8 June 2023

Your Ref: 23/01316/F

**Erection of 5 two storey age restricted dwellings (55 years) for older people with access, landscaping and associated infrastructure - Land South of Faraday House, Woodway Road, Sibford Ferris (Application No. 23/01316/F)**

**Figure 4 – Proposed Site Plan**

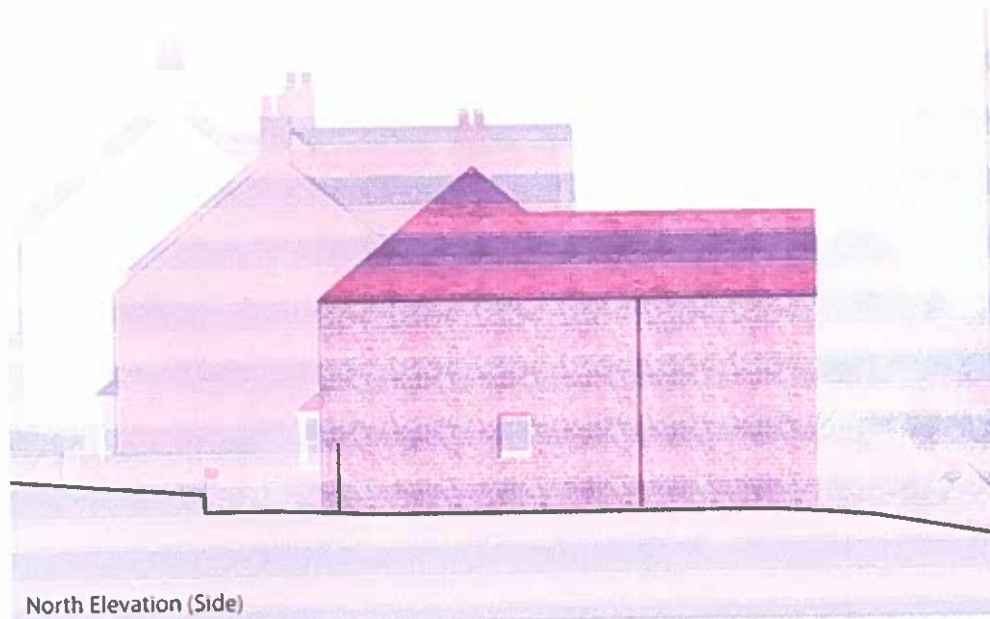
In this particular case, the amended proposal with two-storey dwellings will be accessed via what will become a long access road (circa 225m) serving a total of 30 no. dwellings (i.e. the proposed 5 no dwellings and the 25 no dwellings at Hook Norton Road) running within just a few metres of the private rear gardens of existing dwellings at Woodway Road, Stewart’s Court and Hook Norton Road. The use of this by residents’ vehicles, visitors and service vehicles will cause noise, disturbance and intrusion into what is presently open, rural countryside with very quiet ambient noise levels, which will be detrimental to the tranquil, peaceful residential amenities of existing neighbouring properties.

The close proximity of the proposal to existing dwellings is evident from Figure 4.

Figure 6 – View of Proposal from the North (Faraday House)

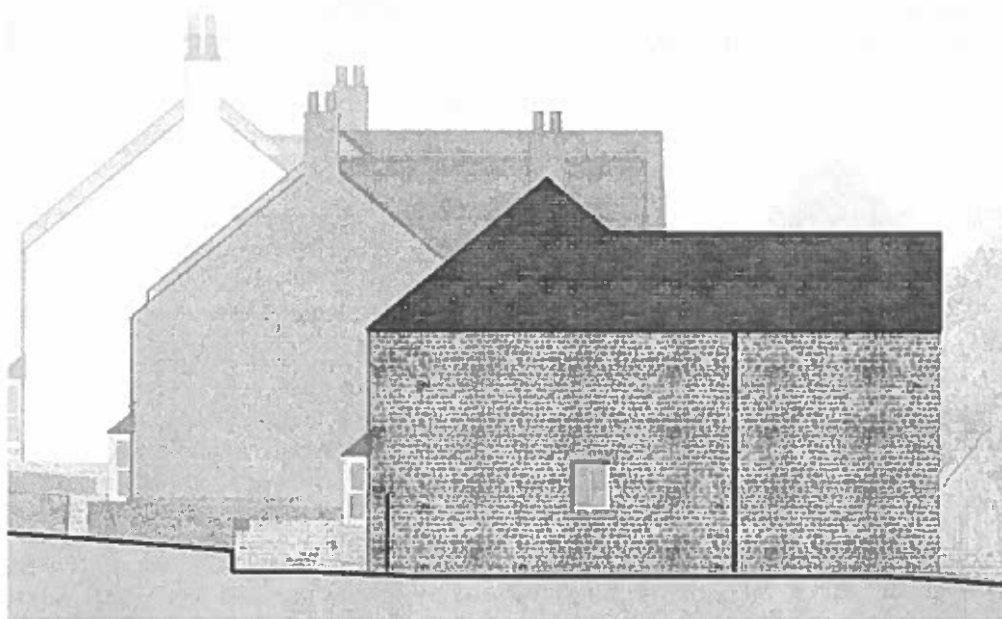
The physical impact of the dwellings – especially Plot 5 – is perhaps most acute upon Faraday House just 15 metres to the north of the site, as shown on Figure 6 taken from the application.
